**Our Ref: AW/335/19/HH**  
**Your Ref:**

**Town & Country Planning Act 1990 (as amended)**  
**Town & Country Planning (Development Management Procedure) (England) Order 2015**  
**Application for Planning Permission for Works or Extension to a Dwelling**

**Development**     Single storey side extension and extension to existing garage  
**Location**        18 Gunwin Court Aldwick

Drawing title
Proposed Site Plan / Block Plan

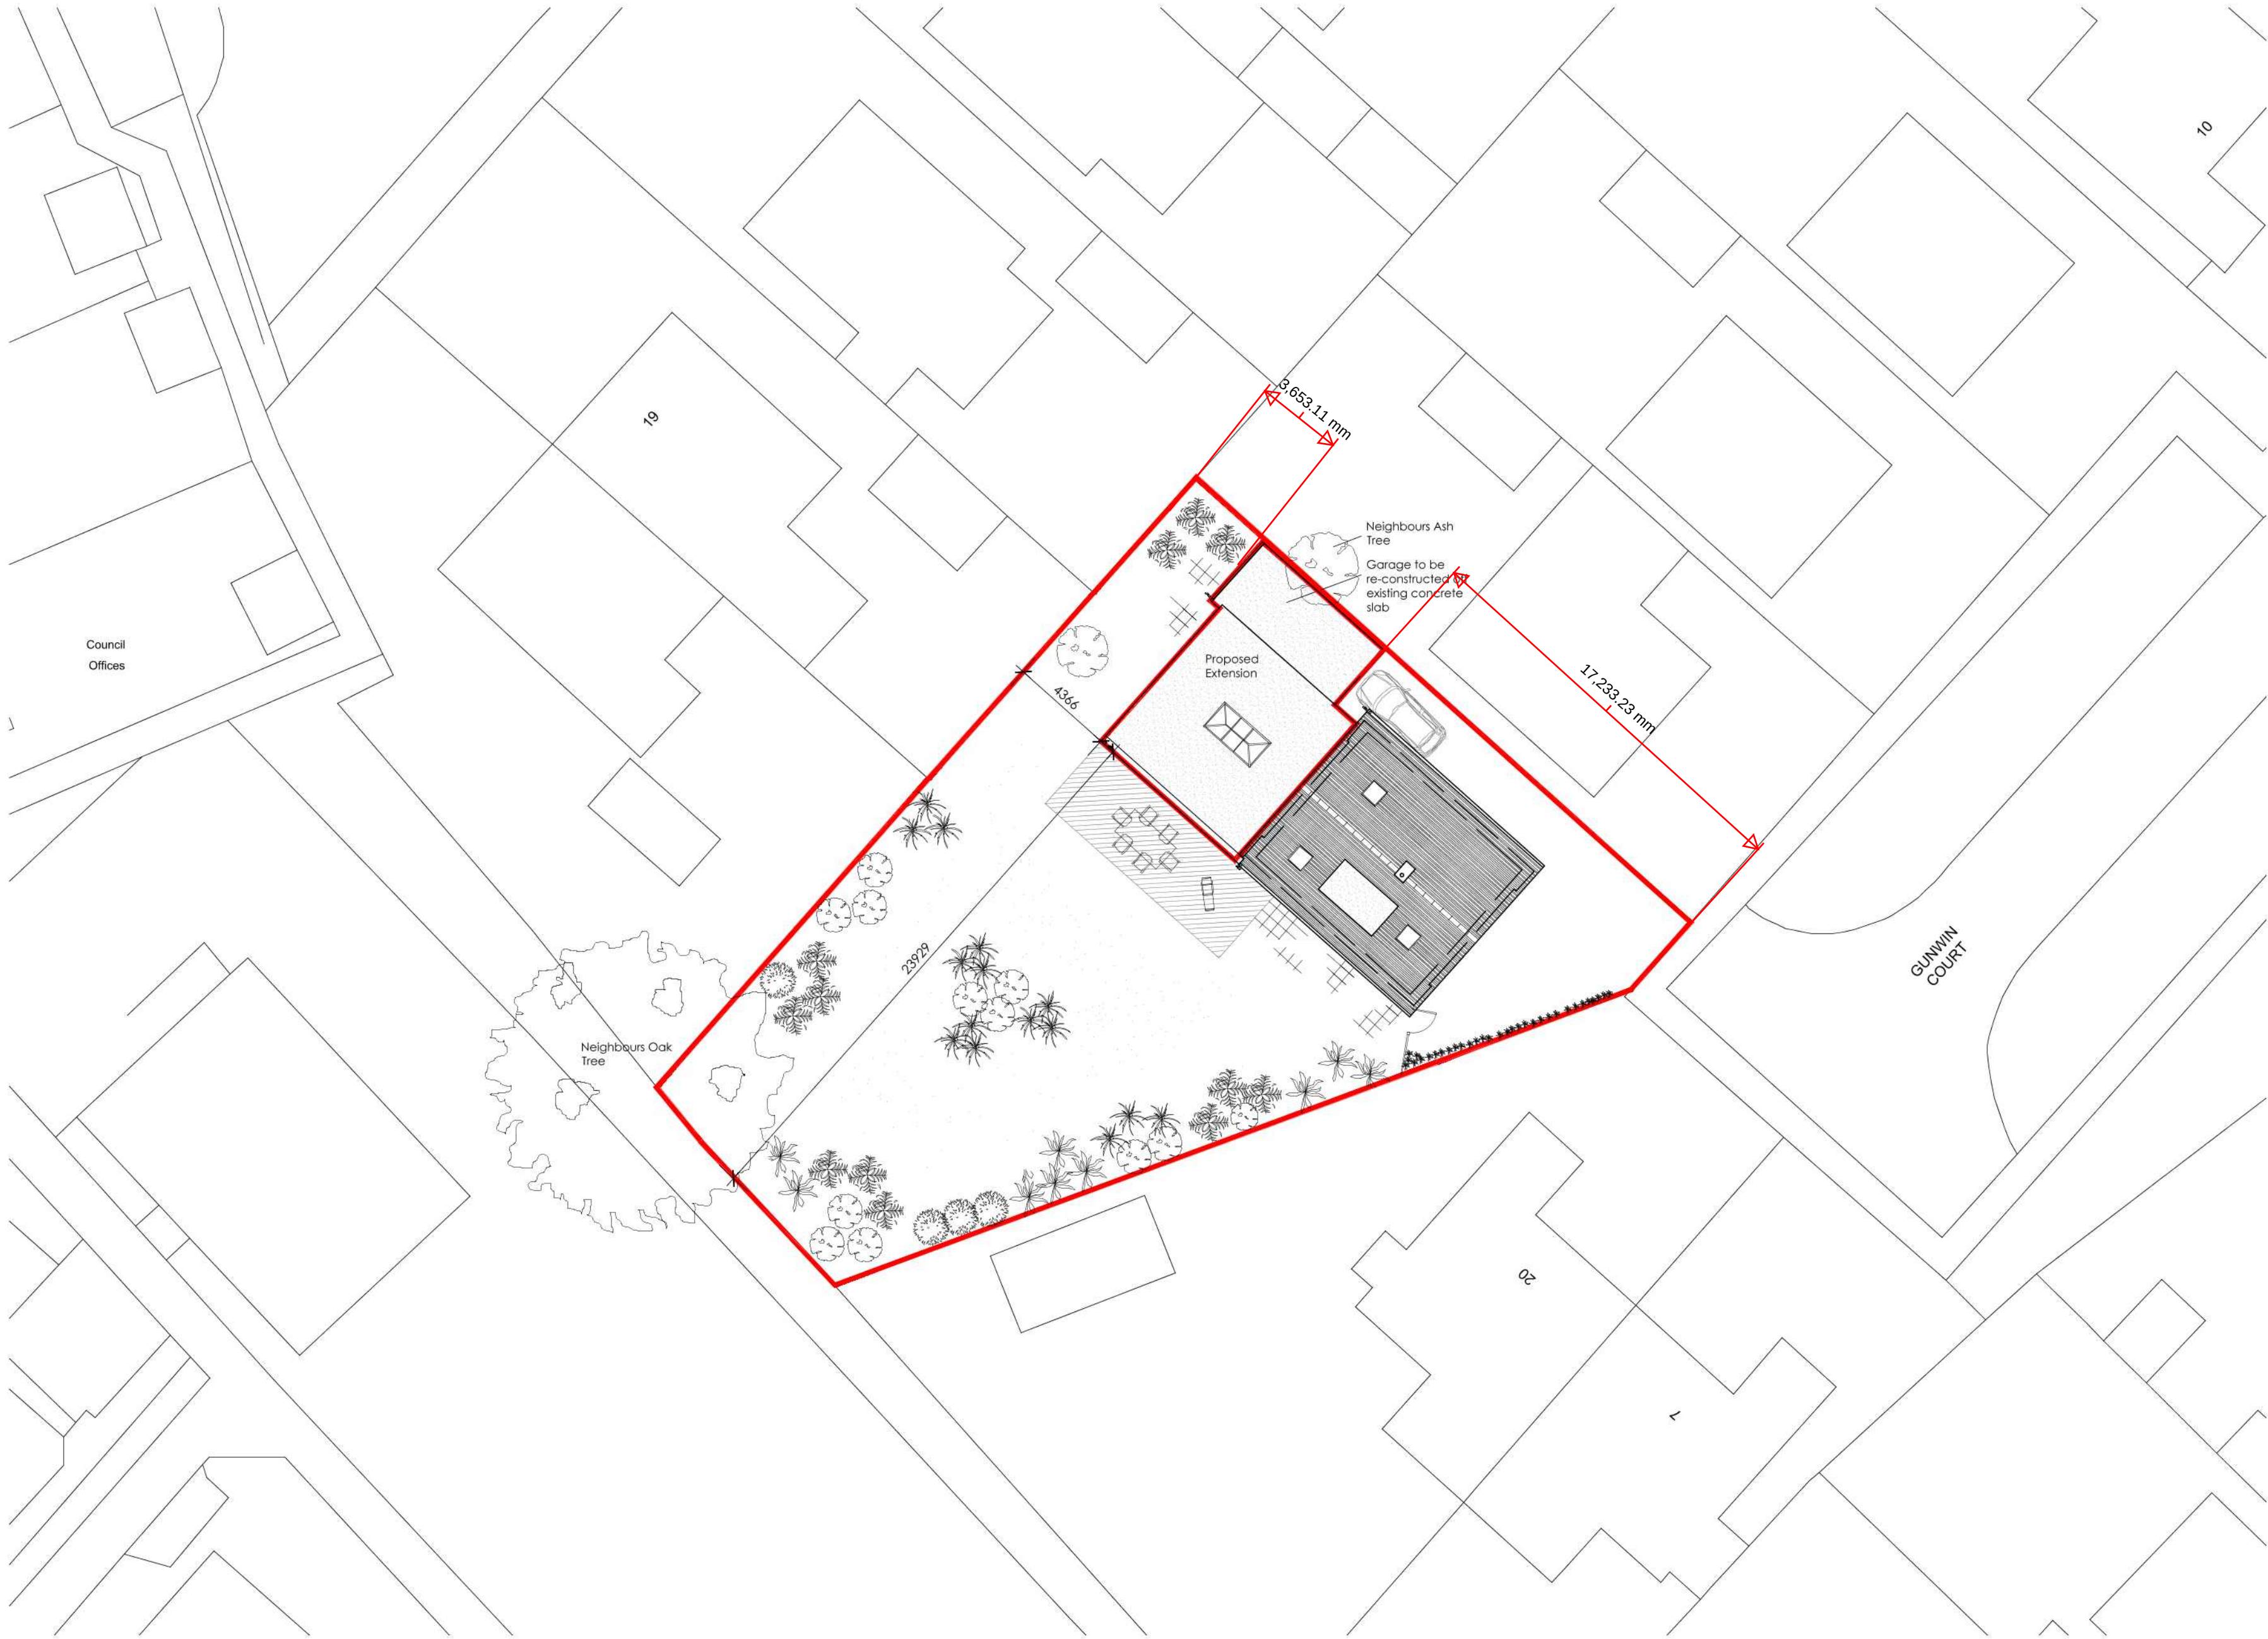
Block Plan: You are required to include a dimension from the garage to all site boundaries.
